CITY OF ALBUQUERQUE

**Re: Plaza Ciudadana Conceptual Grading and Drainage Plan, Engineer's Stamp
Dated 12-05-2011 (H14/D002)**

**C-201**

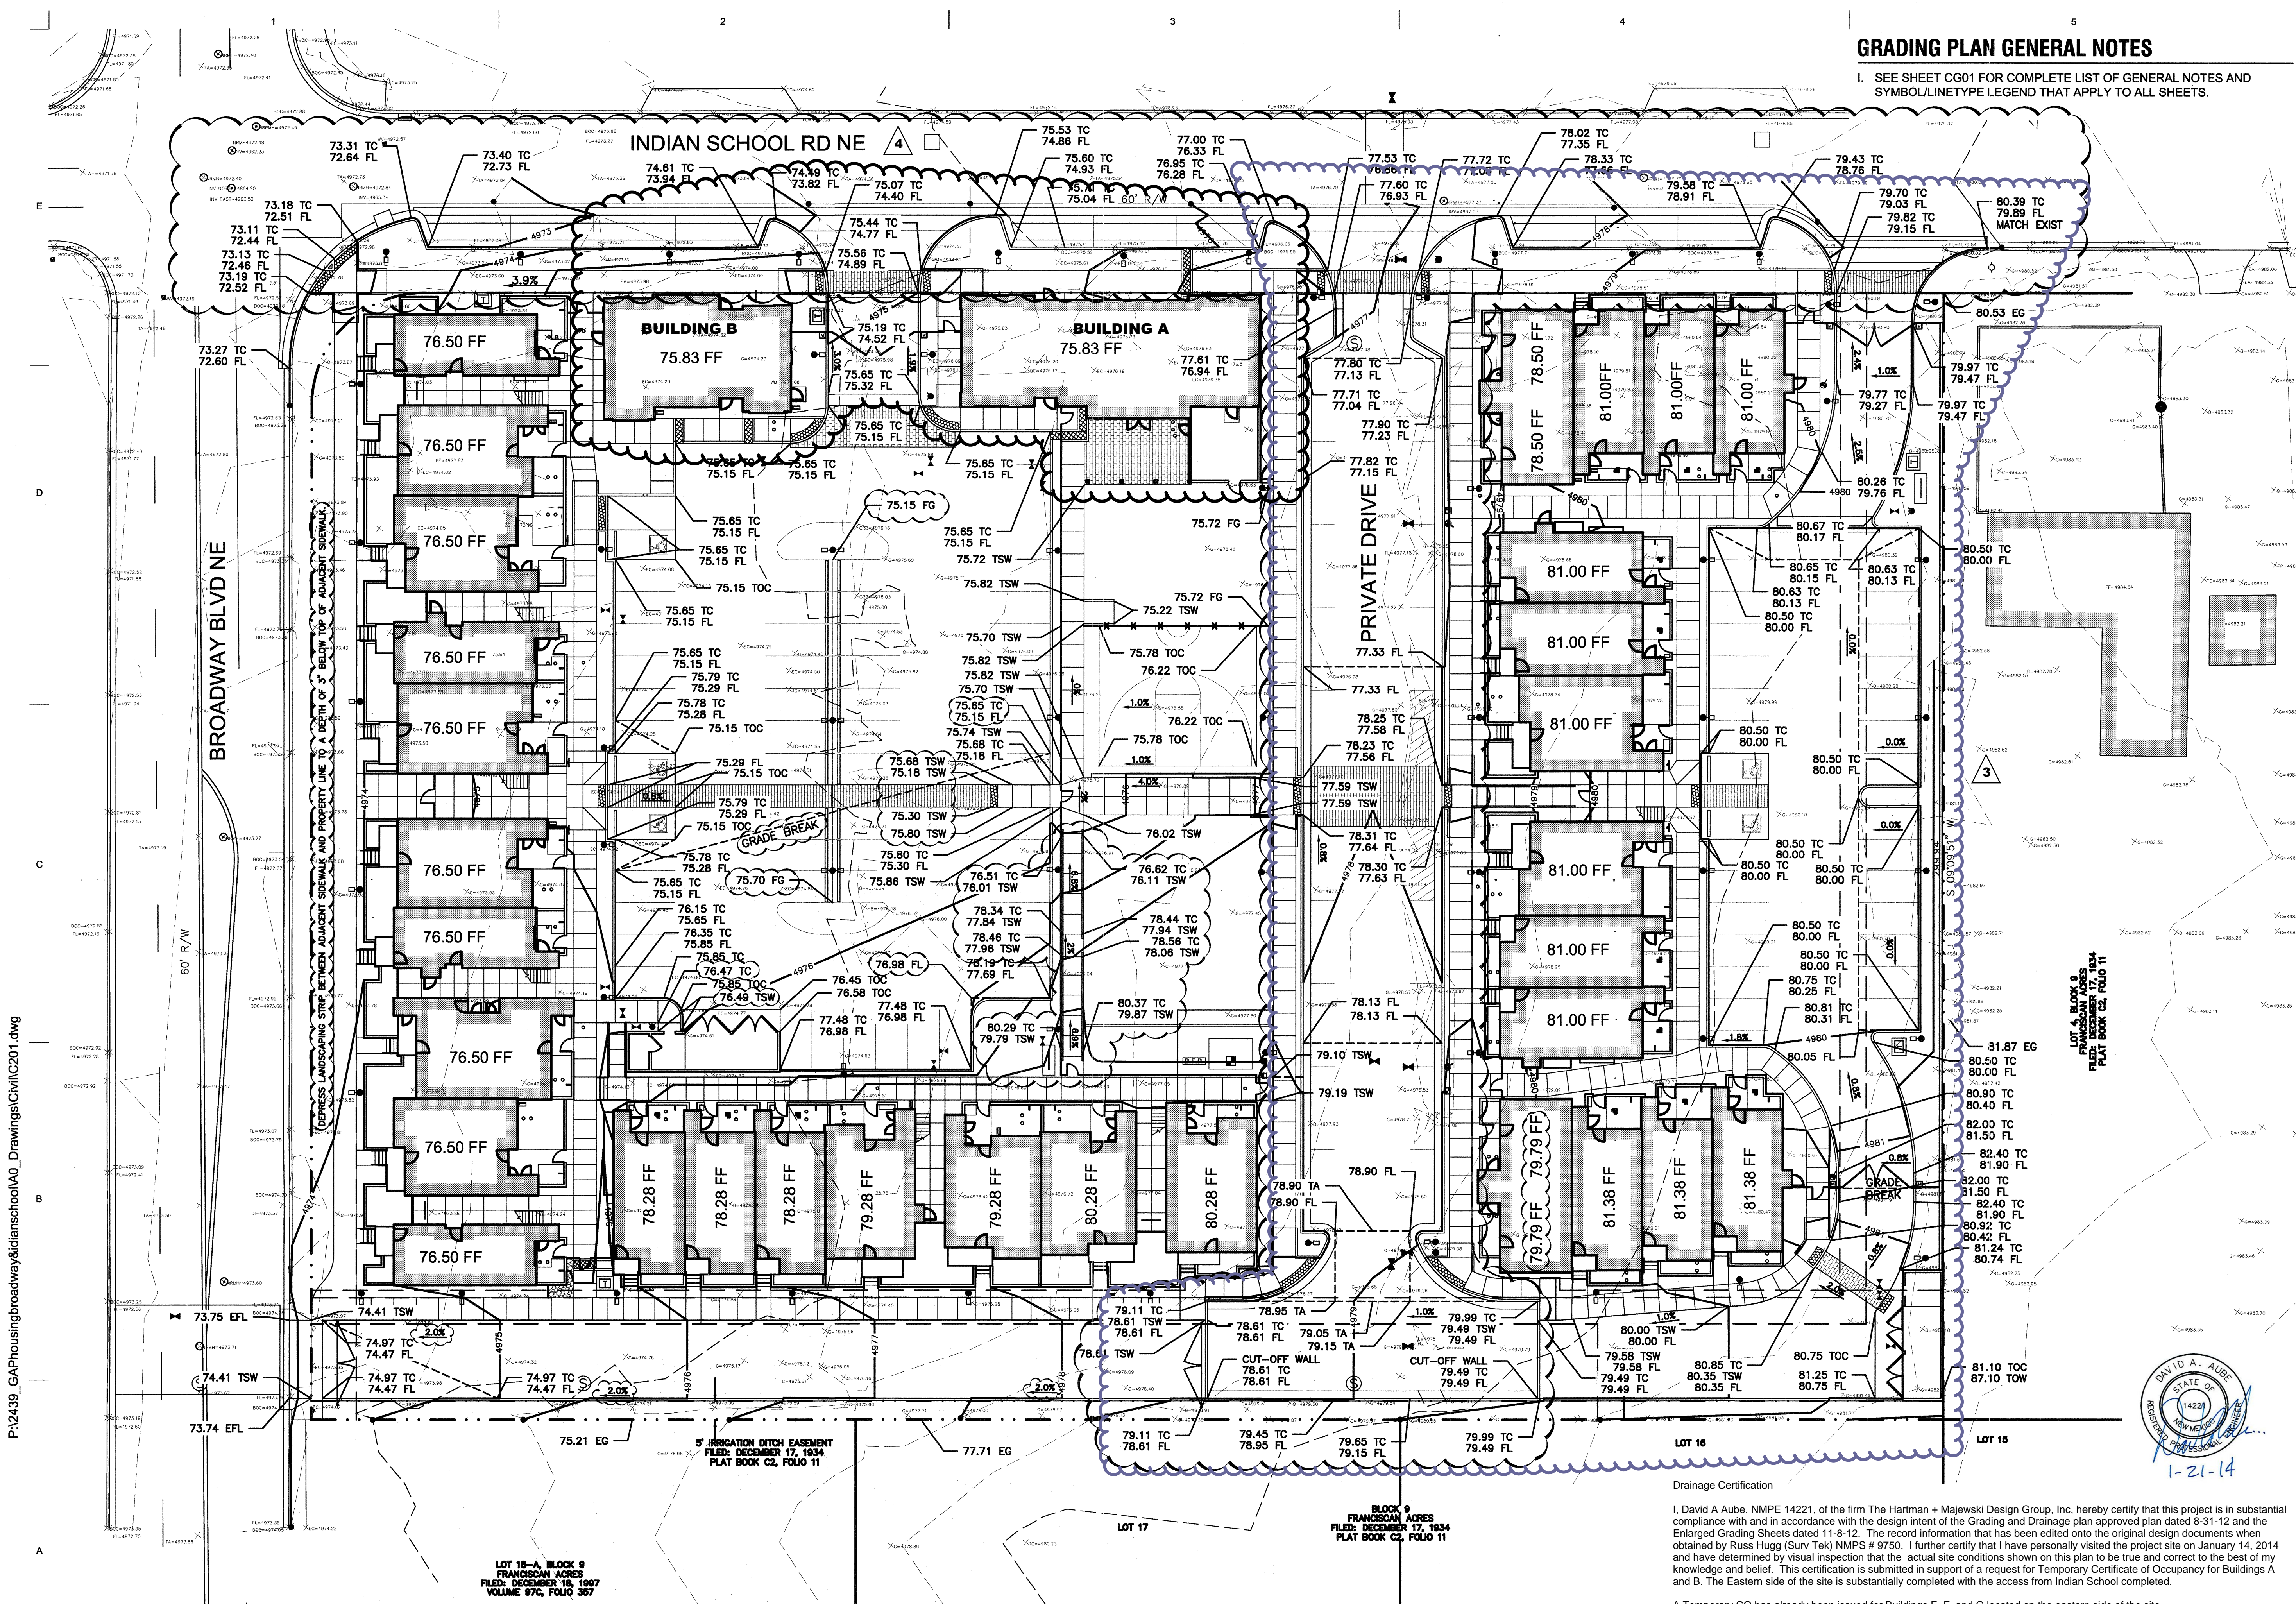
- Show existing topography on sheet CD2.
- Include a Vicinity Map and a City of Albuquerque BM on the plan.
- Add Legends.
- Is the site within a 100-yr floodplain?
- Provide pond calculations for the proposed ponds and show the 100-Year WSEL on the plan.
- Use sidewalk culverts and depressed landscaping areas to avoid draining the runoff over the sidewalks.
- Show additional proposed elevations through out the site.
- Show all the sidewalk culvert locations and sized on the plan. Provide calculations.
- Provide a detail and calculation for the proposed channel to the east.
- Submit a copy of the proposed plat. A cross lot drainage easement will be required.
- Proposed construction on Broadway and Indian School will have to be permitted through a City Work Order. Therefore, plans have to be submitted to Design Review/Construction (DRC) for approval.
